**Chapter V - Section 55
Subdivision Summary Form**

SUBDIVISION NAME:

FALCON MEADOWS AT BENT GRASS FILING NO. 4

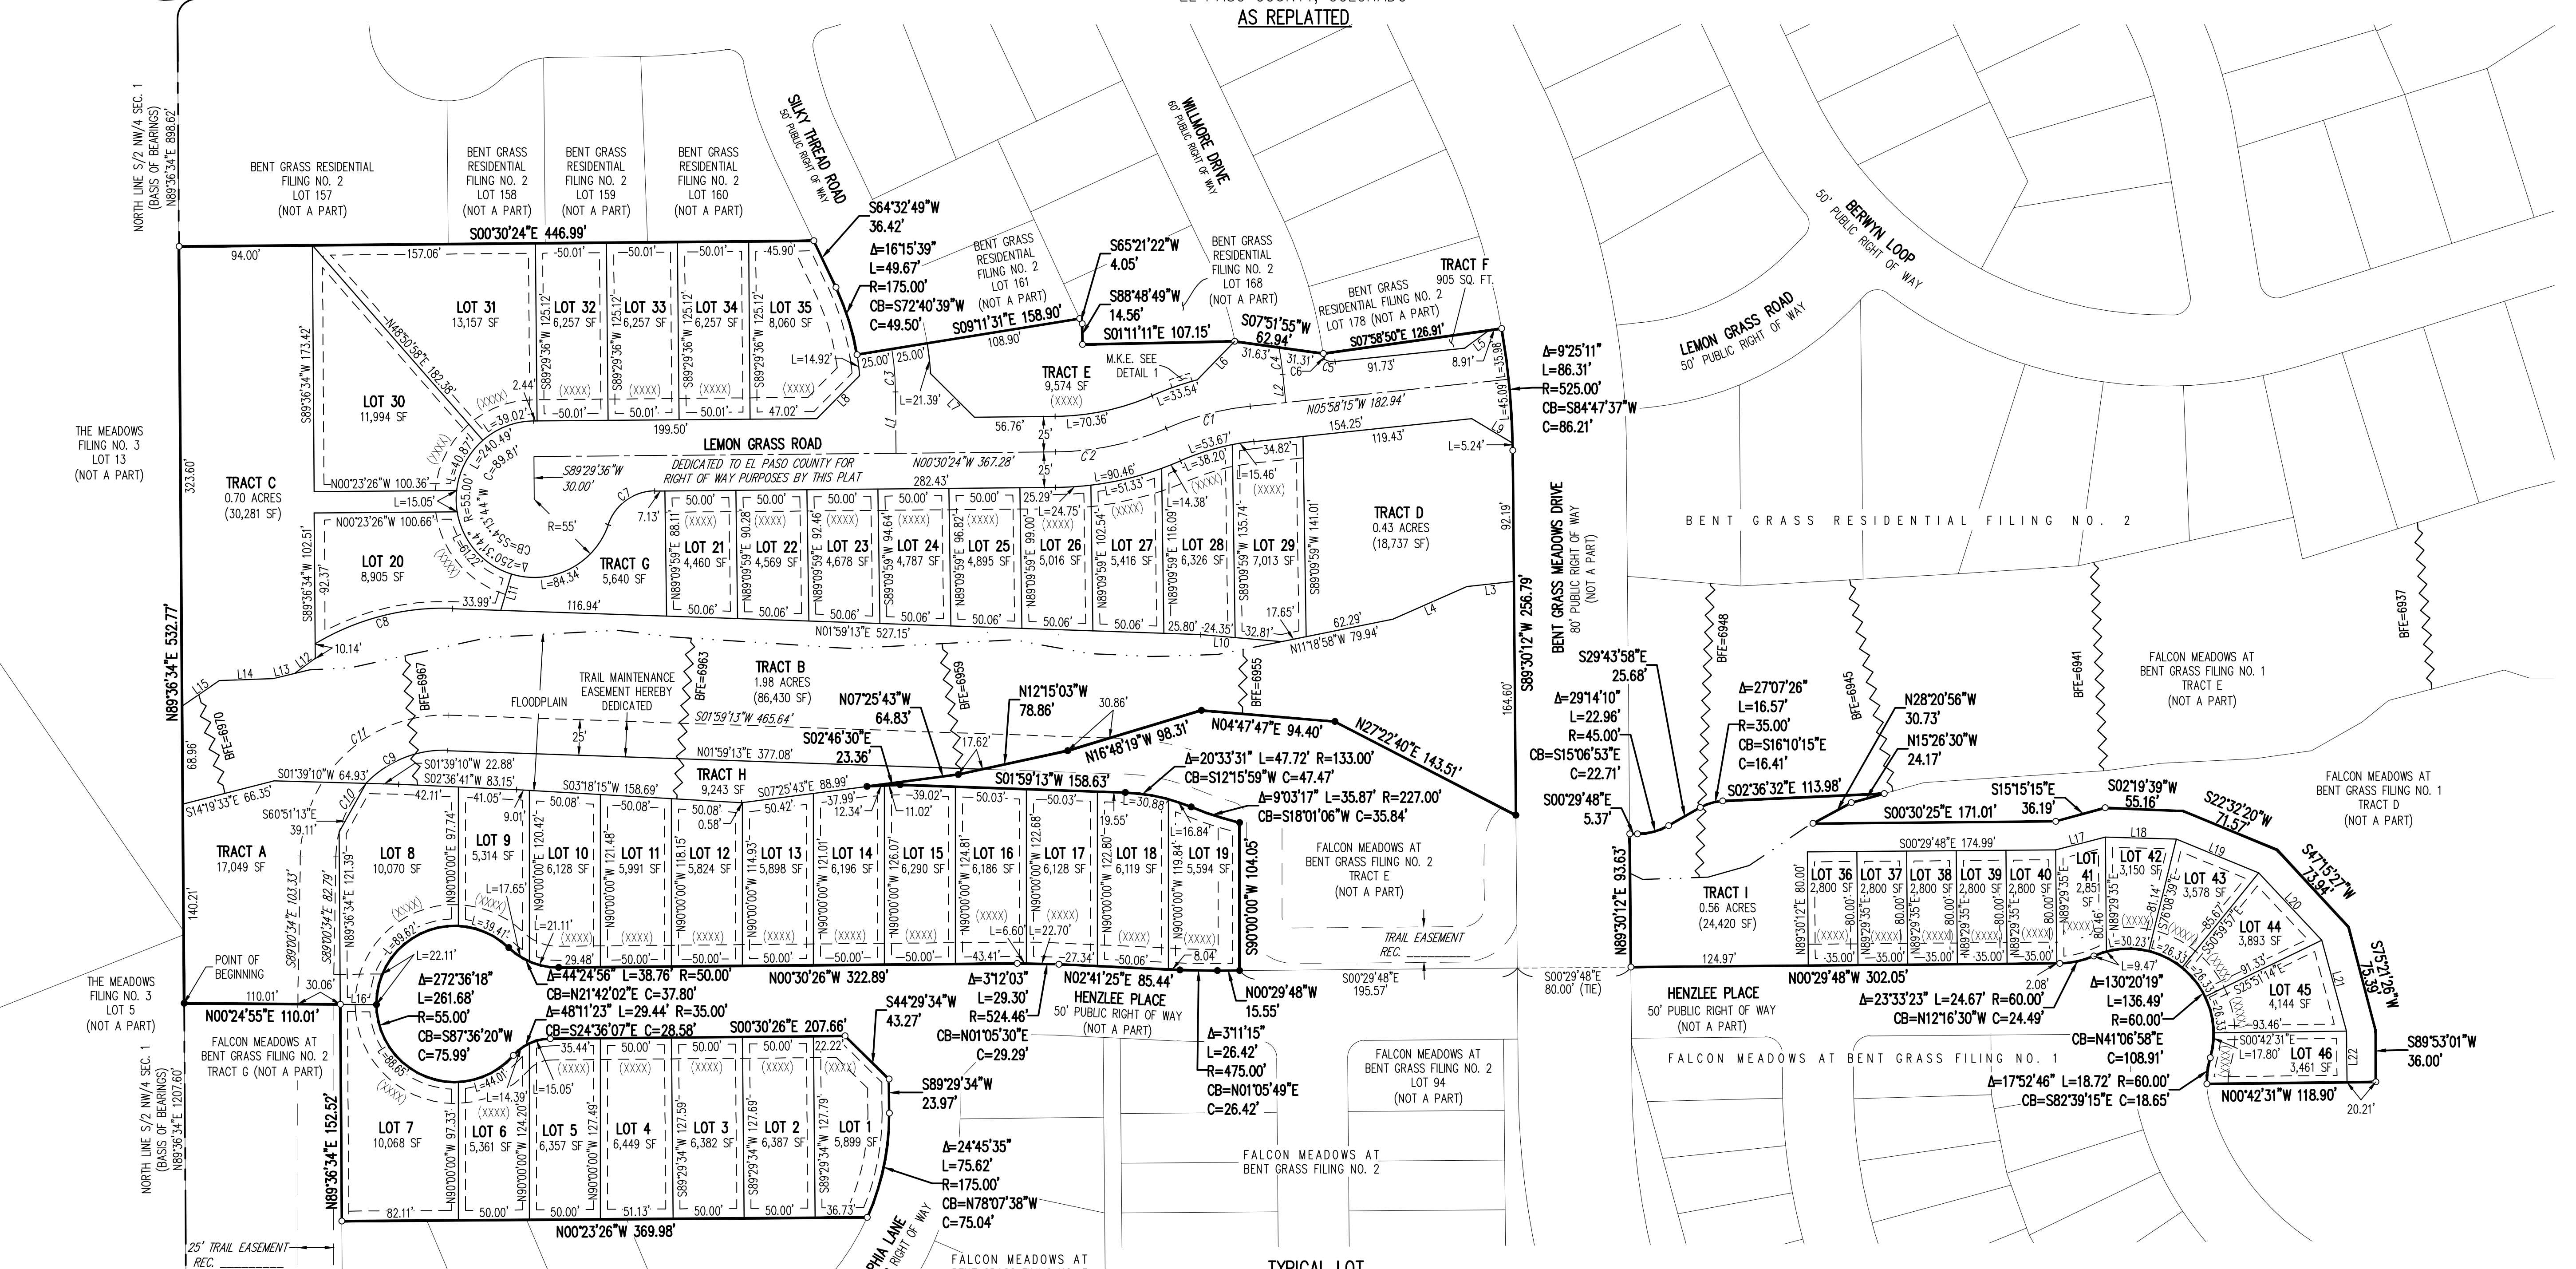
AN ADDITIONAL TRACT HAS BEEN ADDED. IT IS WITHIN AN EXISTING TRACT SO THE AREA REMAINS THE SAME.

← add/adjust per comments → total acres
